From: Maria Tomalova
Sent: 14 August 2019 17:52
To: Planning.Responses <Planning.Responses@arun.gov.uk>
Subject: FW: Re: FP/139/19/OUT, Land south of garage compound

From: Nicola Fry [REDACTED]
Sent: 30 July 2019 08:51
To: Maria Tomalova <Maria.Tomalova@arun.gov.uk>
Subject: FP/139/19/OUT - Land south of garage compound & East of 12 Alfriston Close Felpham PO22 6QE

Outline application with all matters reserved for the erection of 1 No. dwelling.
Land south of garage compound & East of 12 Alfriston Close Felpham

FP/139/19/OUT, Land south of garage compound BLOCK PLAN 1:200 scale

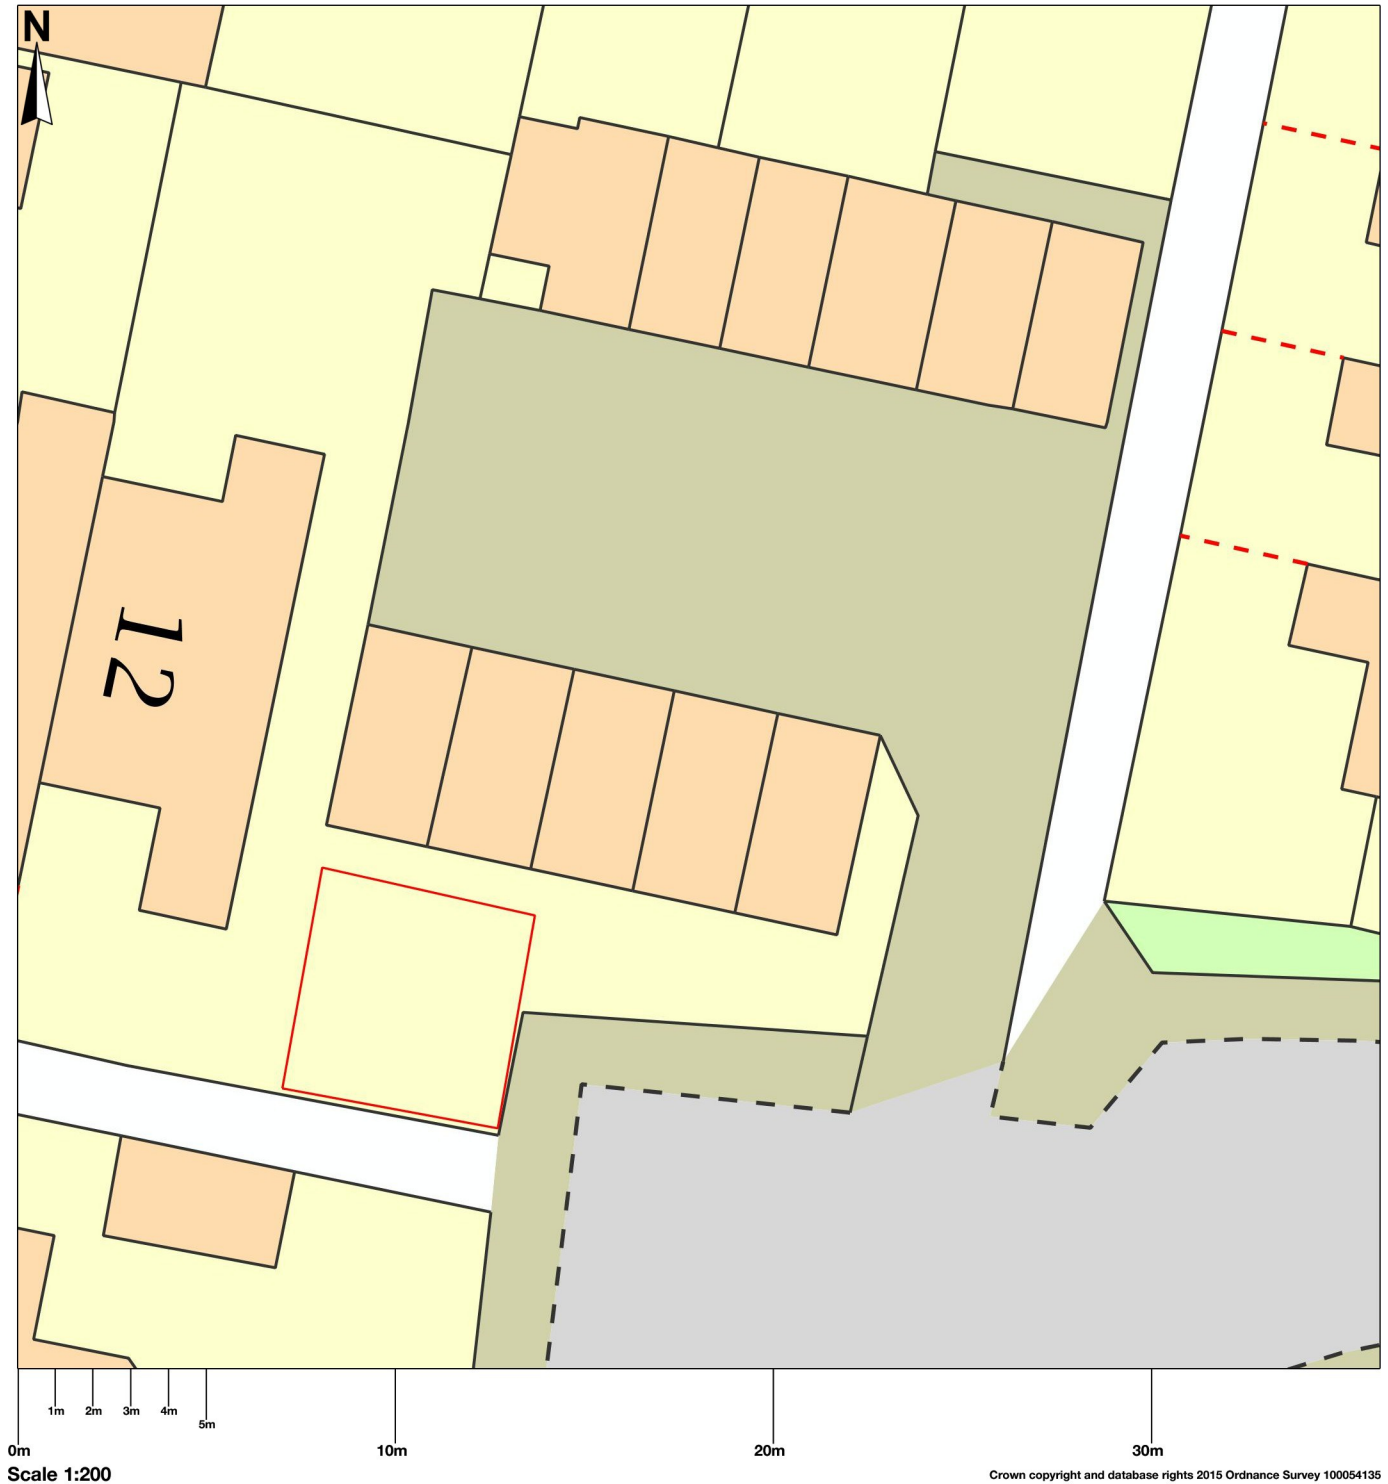
There appears to have been a misunderstanding of the original block plan, in that the building would cover the footway and prevent its use. The email to you from Nicola Fry and numerous other objectors seem to have gained this impression which appears to be growing in momentum but the premise is not correct!

Further to comments provided by my colleague Kyran Schneider on 18th July 2019, the WSCC Area Engineer has contacted me with concerns regarding this proposal in relation to the footway. Specifically they are concerned that the applicant intends to build on this land, which is publically maintained highway.

Having inspected local mapping, it appears that the whole site is classified as publically maintained highway. In order for the land to be incorporated into the site, the highway rights would need to be formally removed by way of a Stopping Up Order. This is controlled by Section 247 of Town and Country Planning Act and would be subject to a separate process administered by the Department for Transport's National Casework Team. The Highway Authority along with other statutory undertakers and interested parties would be consultees in this process. There is also no guarantee that this process would be successful. The comments made here would not constitute the Highway Authority's formal position regarding any future Stopping Up. The applicant should be aware that the LHA would not wish to see any loss of footway width in this location. This does appear to have been acknowledged by the applicant in comments dated 29th July.

Please can it be made very clear this is not the case.

Equally that the building would not impact on either of the trees and will deliberately avoid them.

3/ the street light and pedestrian access would again not be affected, this is a misinterpretation of the block plan document.
